Please ask for: Nicola Moore
Email: nicola.moore@arun.gov.uk
Telephone: Ext 37944
Our Ref: R/260/21/CLP
Your Ref:
Date: 19th October 2021

Lawful Development Certificate for a Proposed Use or Development

Development: Lawful development certificate for the proposed erection of detached garden room.
Location: 1 Pigeonhouse Lane Rustington BN16 2AY

Drawing Title: PROPOSED BLOCK PLAN

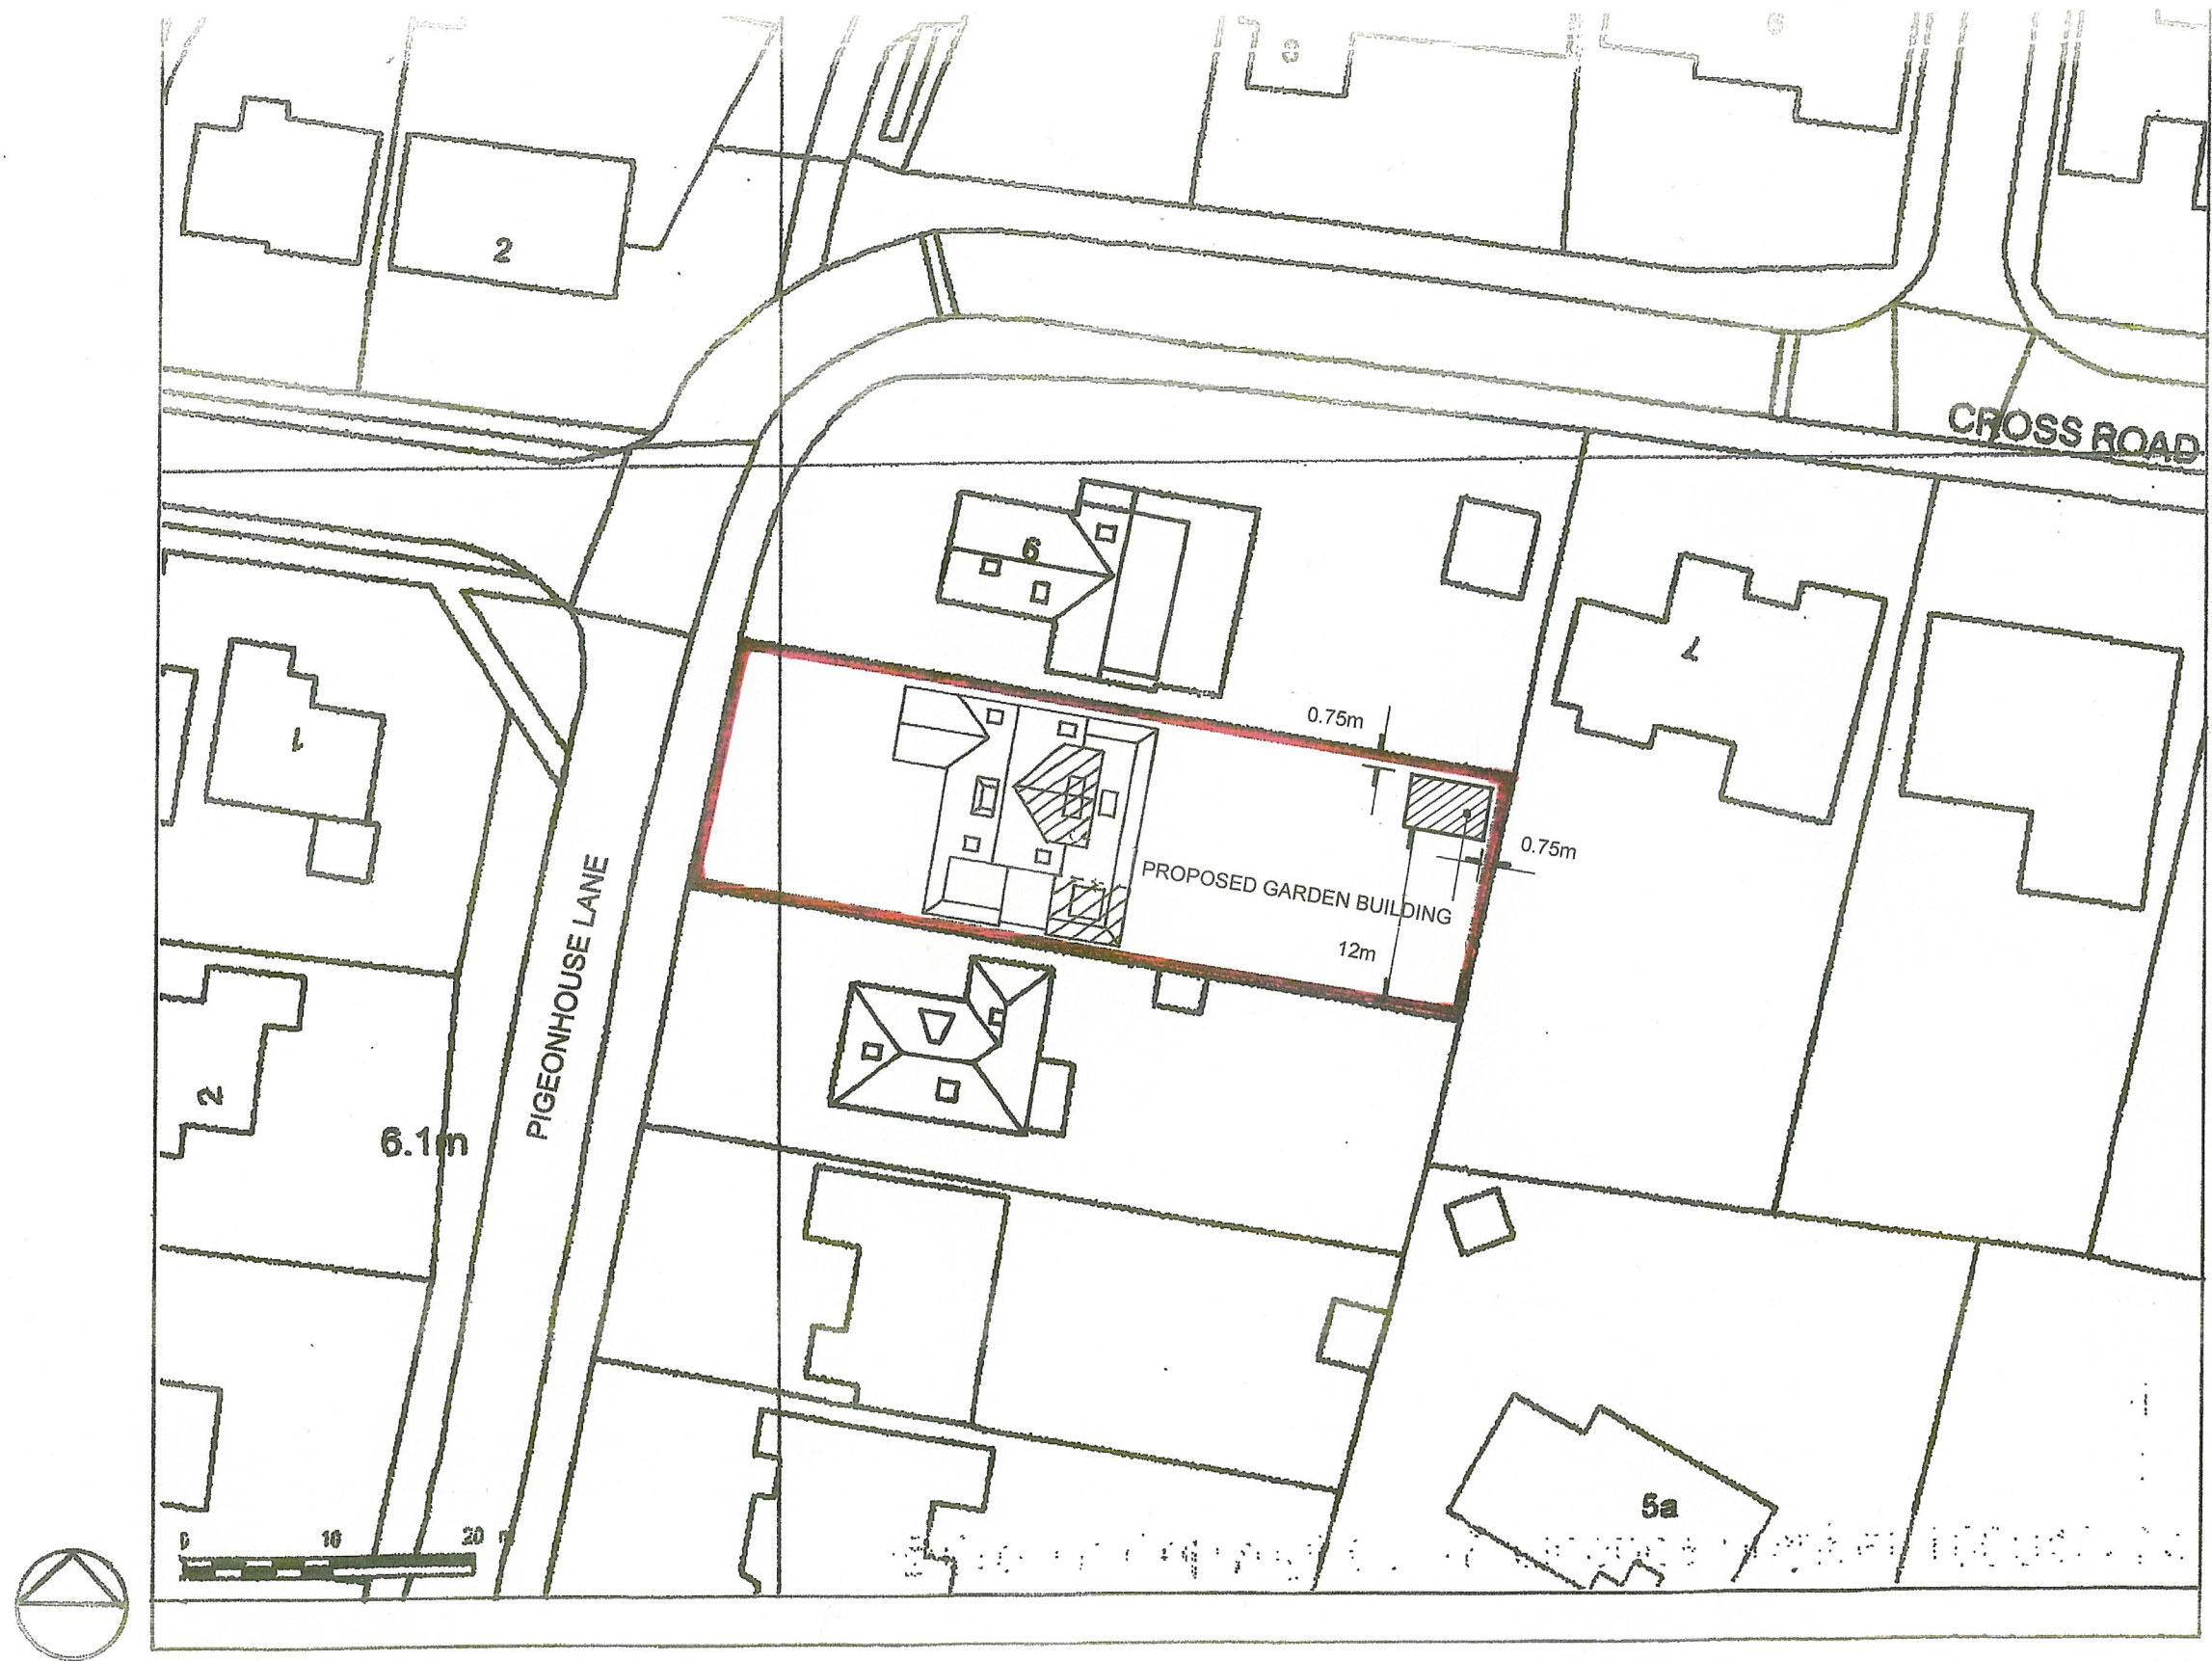
Block Plan

Please amend the Block Plan to include the distances to boundaries from the proposed development and re submit. Further details of what must be included on the plan can be found in the Validation Requirements List.
